Job No. 191726

Re: Road Certification Letter – Restriping and Public Improvements  
Foundation Lutheran Church  
9960 Towner Av  
TR C, Paint Brush Hills, Filing No. 13A  
Falcon, Colorado

Reference Drawing: Restriping and Public Improvements As-Built, by RMG, Job No. 191726,  
January 15, 2025.

SHEET NAME <b>RESTRIPIING AND PUBLIC IMPROVEMENTS AS-BUILT</b>		PROJECT STATUS <b>SITE DEVELOPMENT PLAN</b>	
ENG:	BG	DRAWN:	CL
CHECKED:	BG	DATE:	01-15-25
#	REVISION	DATE	
JOB NO.	191726		
SHEET NO.	01		
	1 of 1

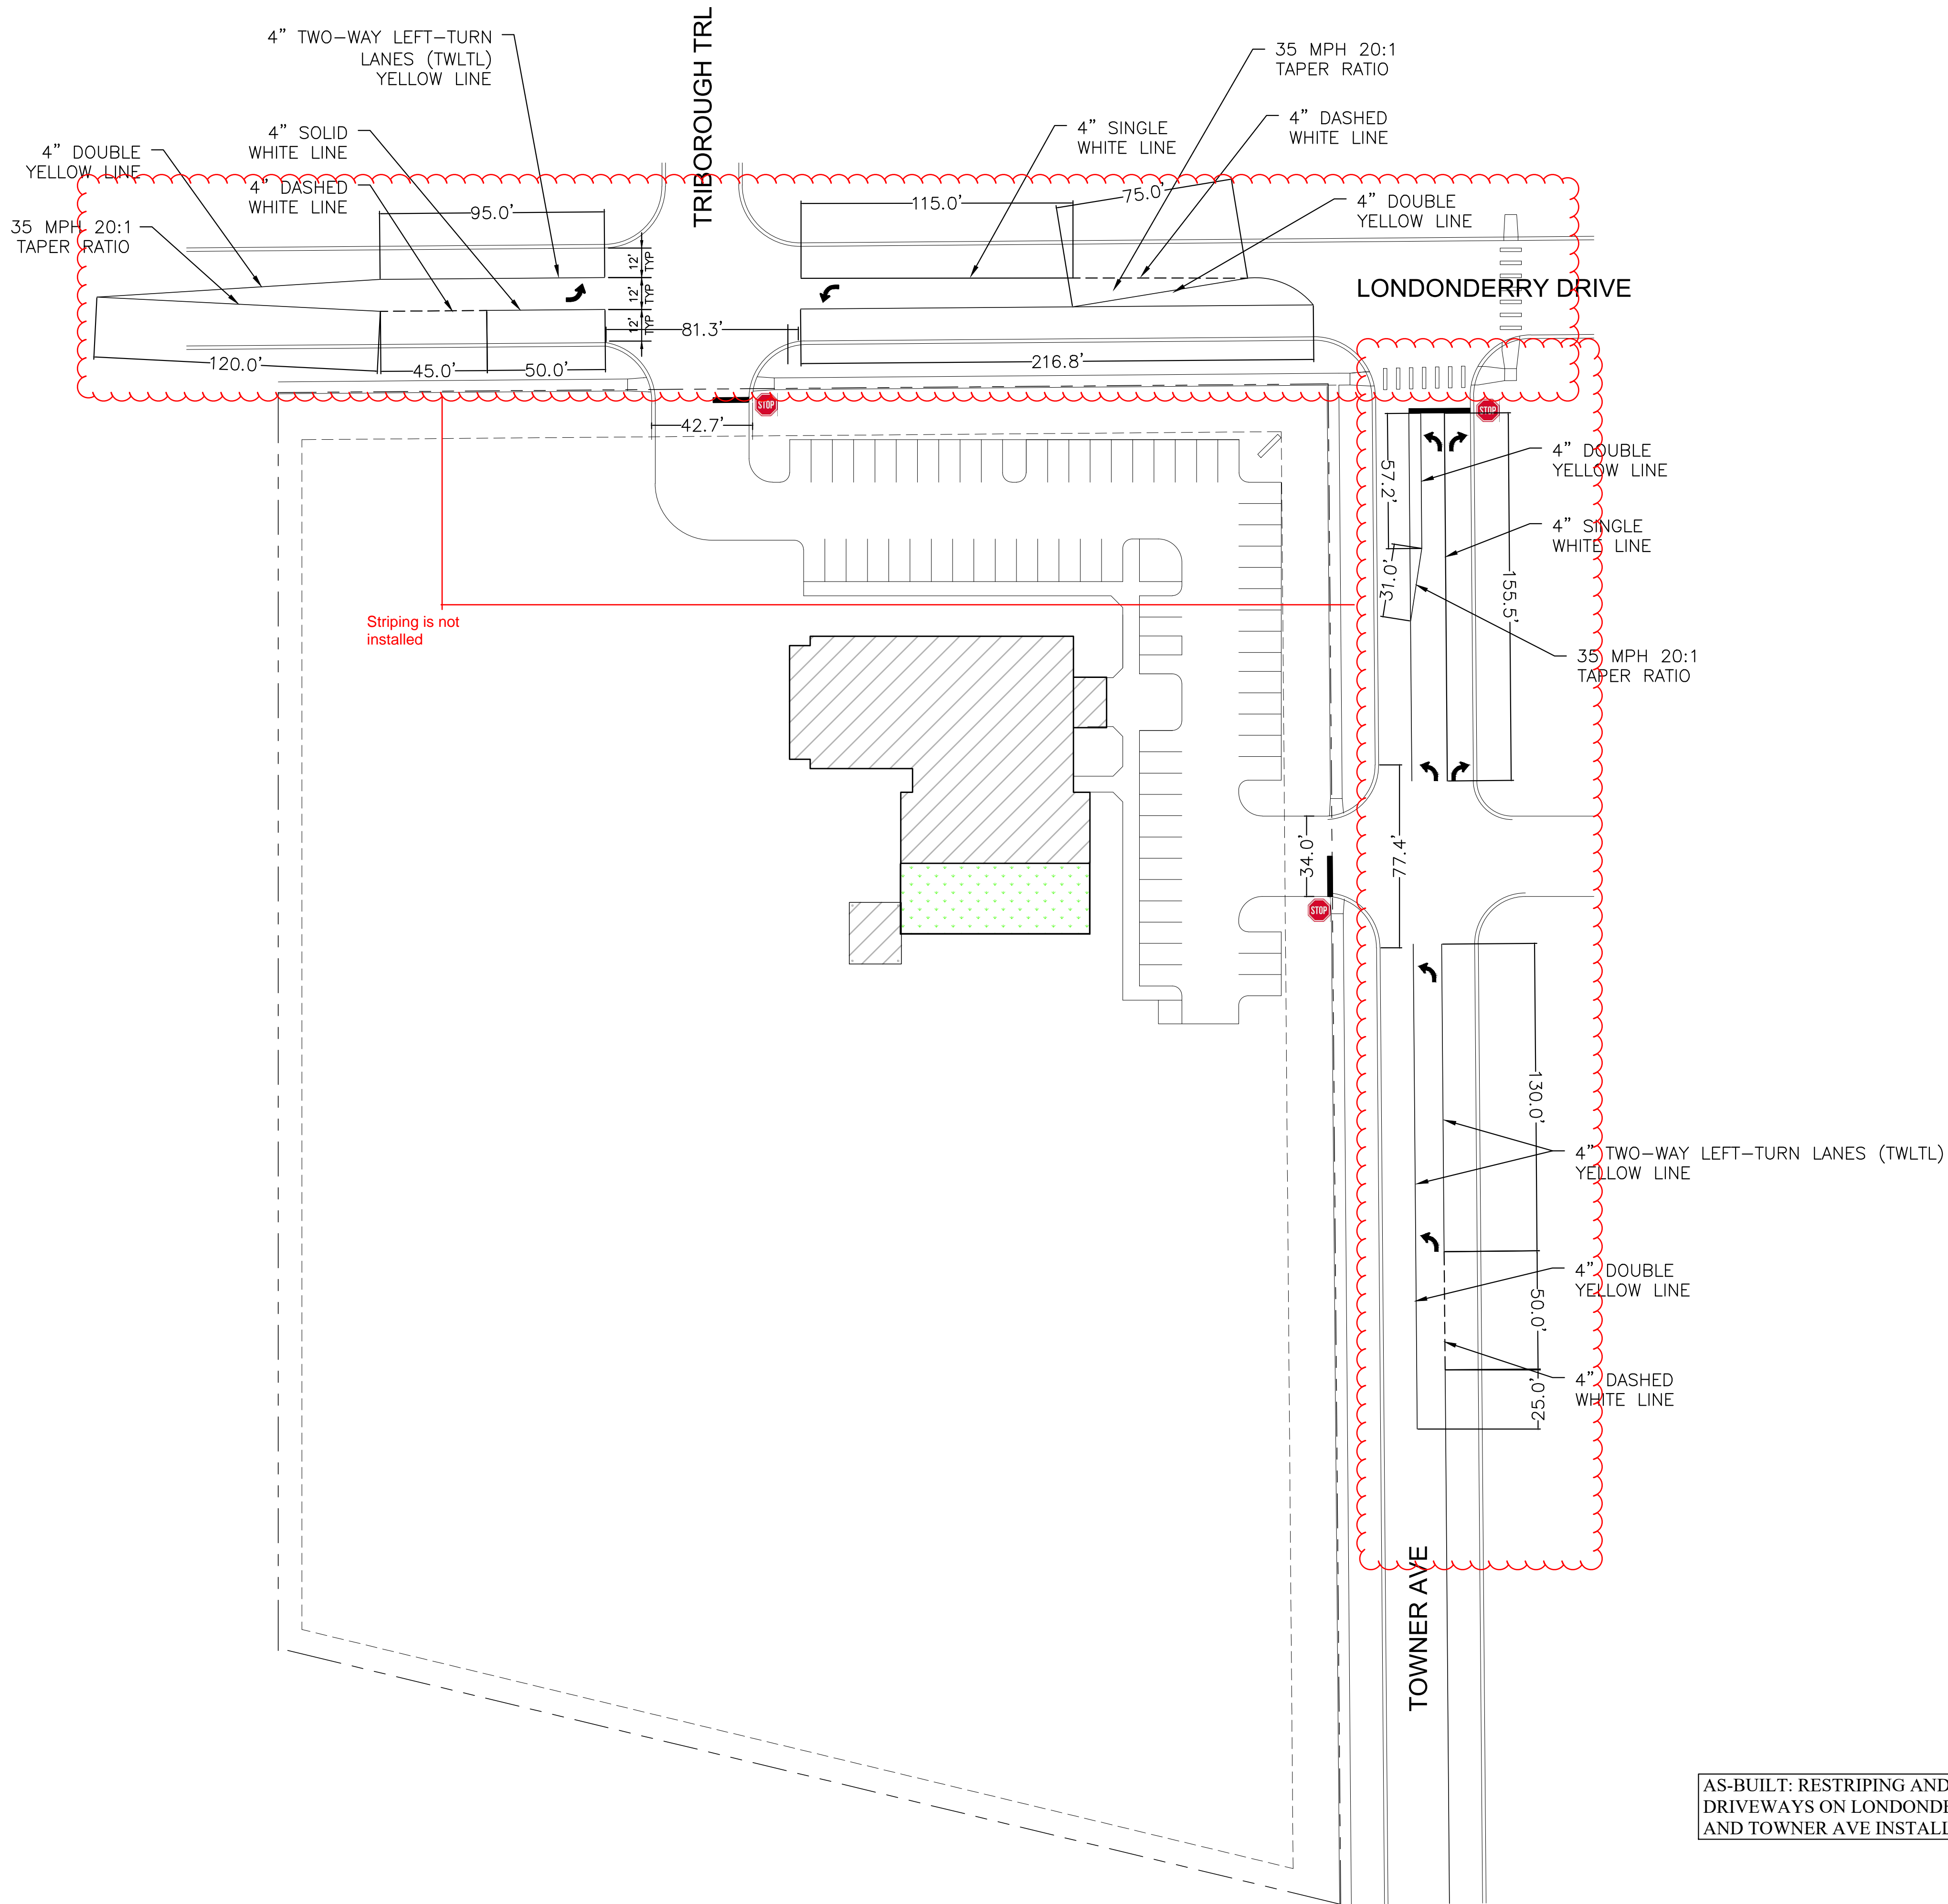
Restriping is not  
complete
